**Item No.**                      **Report of the Head of Planning, Sport and Green Spaces**

**Address**                      12 HARVIL ROAD ICKENHAM

**Development:**              Conservatory to rear and detached garage to rear

**LBH Ref Nos:**              **12371/APP/2015/2608**

DRAWING NO.	2015/772/P07	DATE	June '15		
					SCALE	1:200@A3	REV.	A

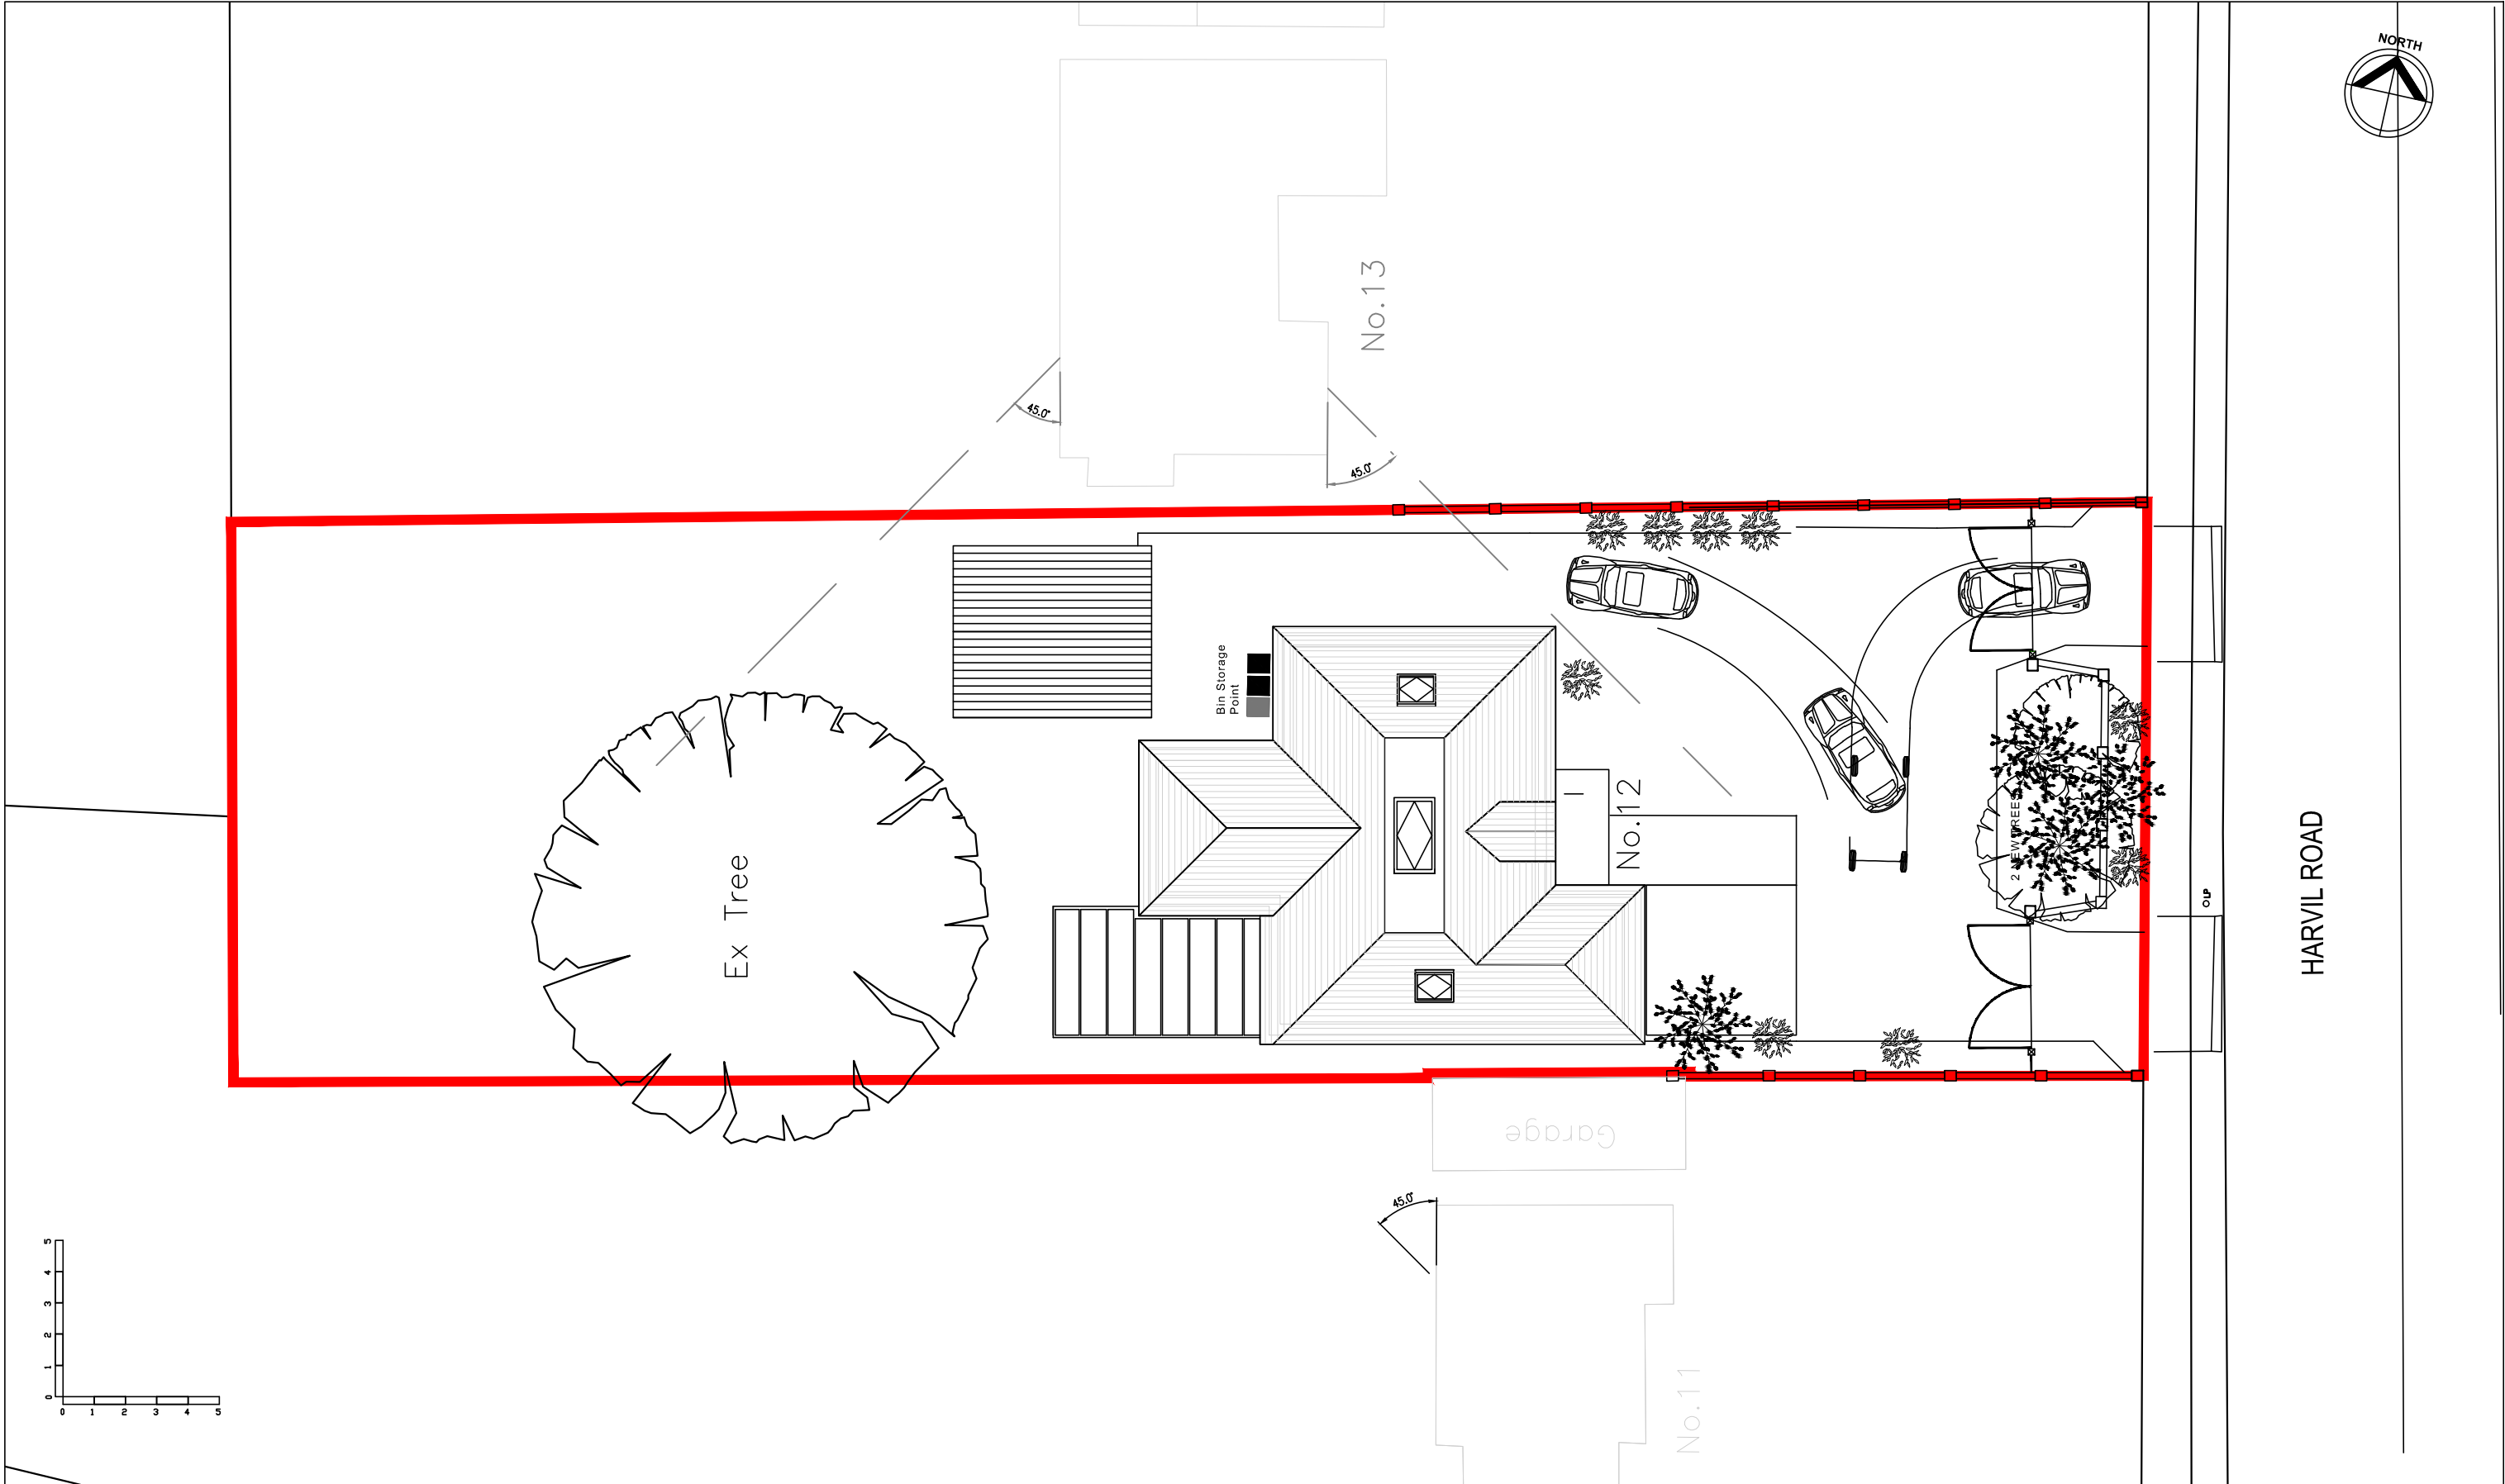
There is a large, mature, protected Oak in the rear garden. The proposed buildings are likely to be within the tree's RPA's. The applicant has failed to show that this scheme makes adequate provision for the protection and long-term retention of valuable trees and is contrary to Policy BE38 of the Hillingdon Local Plan: Part Two - Saved UDP Policies (November 2012).

In the absence of a Tree Survey, Tree Protection Plan and Arboricultural Method Statement, the application has failed to demonstrate that the development would safeguard existing trees on the site and further fails to demonstrate protection for and long-term retention of the trees. The proposal is therefore contrary to Policy BE38 of the Hillingdon Local Plan: Part Two - Saved UDP Policies (November 2012) and the adopted Supplementary Planning Document HDAS: Residential Extensions.

DRAWING NO.	2015/772/P08	DATE	June '15		
				SCALE	1:50@A3	REV.

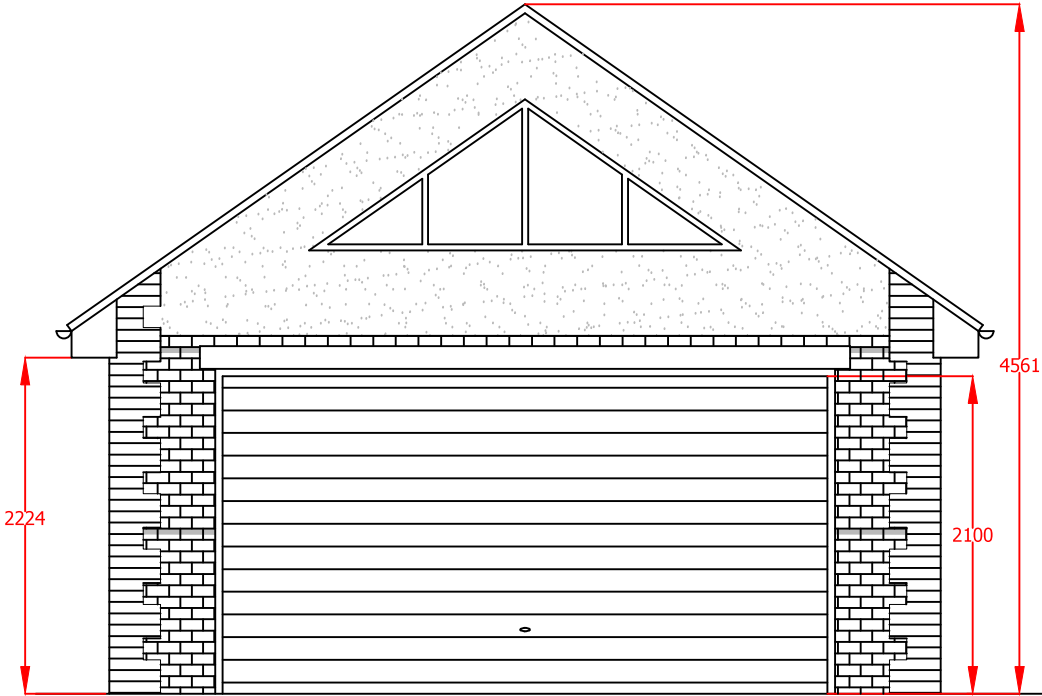
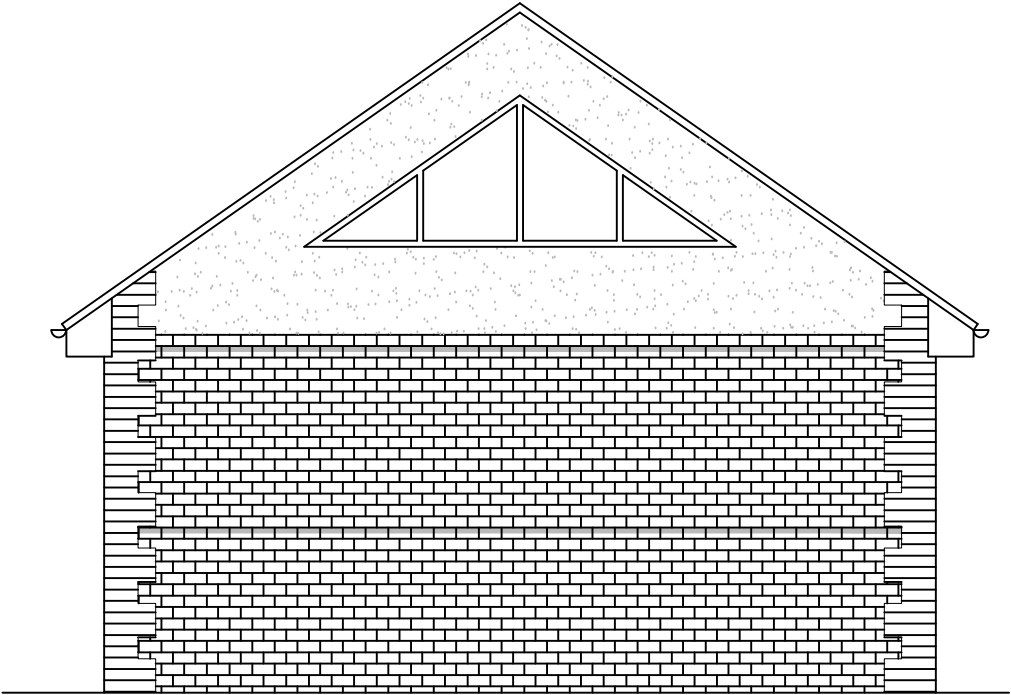
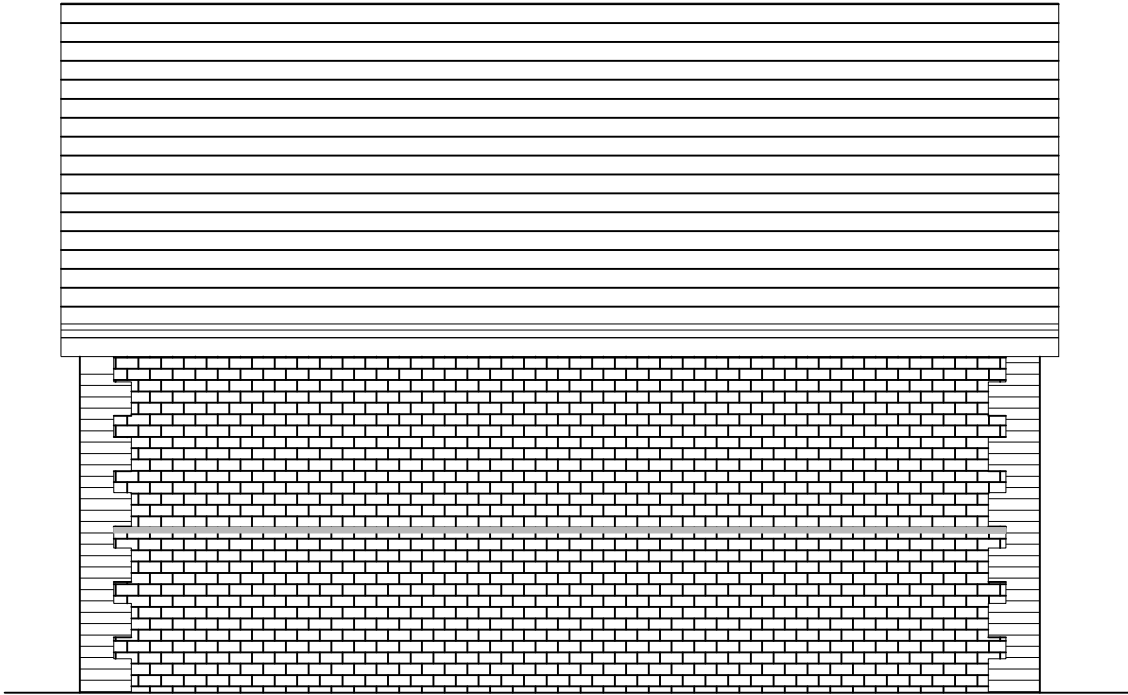
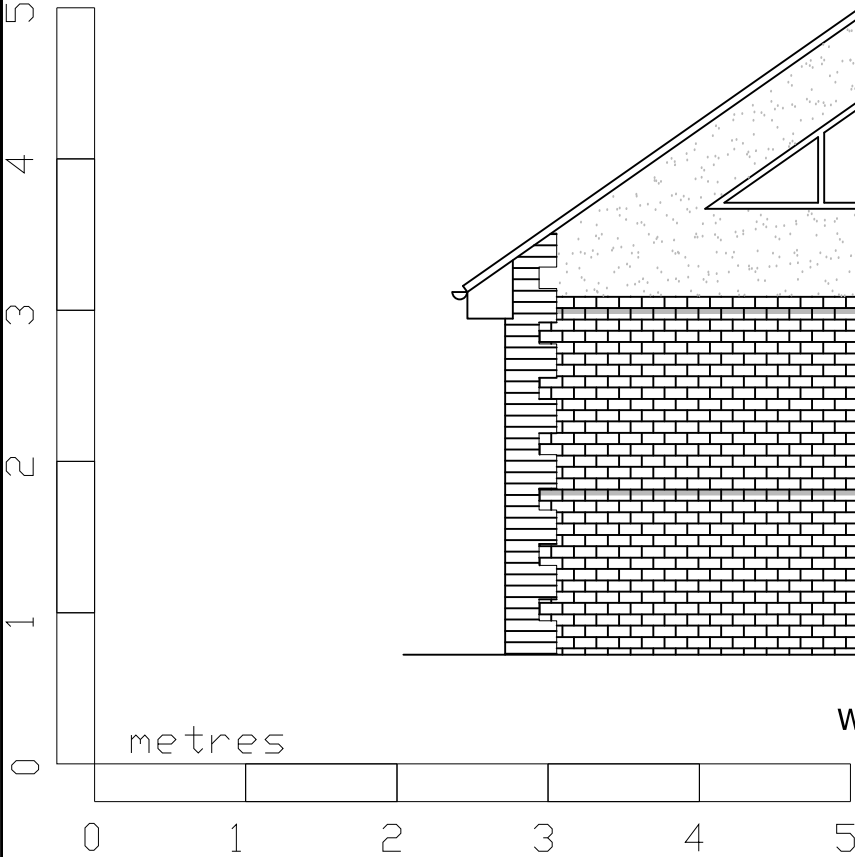
Given the location of the proposed garage close to the boundary of the property, its overall height, size, scale and siting between the large gap between the application and adjoining property, the garage would be highly visible from the street and is considered to detract from the visual amenities of the surrounding area. As such, the proposal would be in conflict with Policy BE1 of the Hillingdon Local Plan: Part One - Strategic Policies (November 2012) and Policies BE13 and BE15 of the Hillingdon Local Plan: Part Two - Saved UDP Policies (November 2012).

Policies BE20 (daylight/sunlight), BE21 (bulk and proximity) and BE24 (privacy) of the Local Plan seek to safeguard neighbouring residential amenities. In this regard, the proposed garage would be approximately set in 1m from the shared boundary with No.13, which has no habitable windows along the side of the property facing the proposed garage. The proposed rear extension would result in no significant loss of daylight, sunlight or visual intrusion to the nearest property at No. 11 and 14. Given the separation distance the extension would be unlikely to be intrusive in terms of their daylight and sunlight or dominate their outlook given that the proposal would not impinge on the 45 degree line of sight from the nearest habitable room window on both properties.

The proposed garage, by reason of its siting, size, scale, bulk and overall height would be detrimental to the character, appearance and visual amenities of the street scene and the wider area. The proposal is therefore contrary to Policy BE1 of the Hillingdon Local Plan: Part One - Strategic Policies (November 2012), Policies BE13, BE15 and BE19 of the Hillingdon Local Plan: Part Two - Unitary Development Plan Saved Policies (November 2012) and the adopted Supplementary Planning Document HDAS:
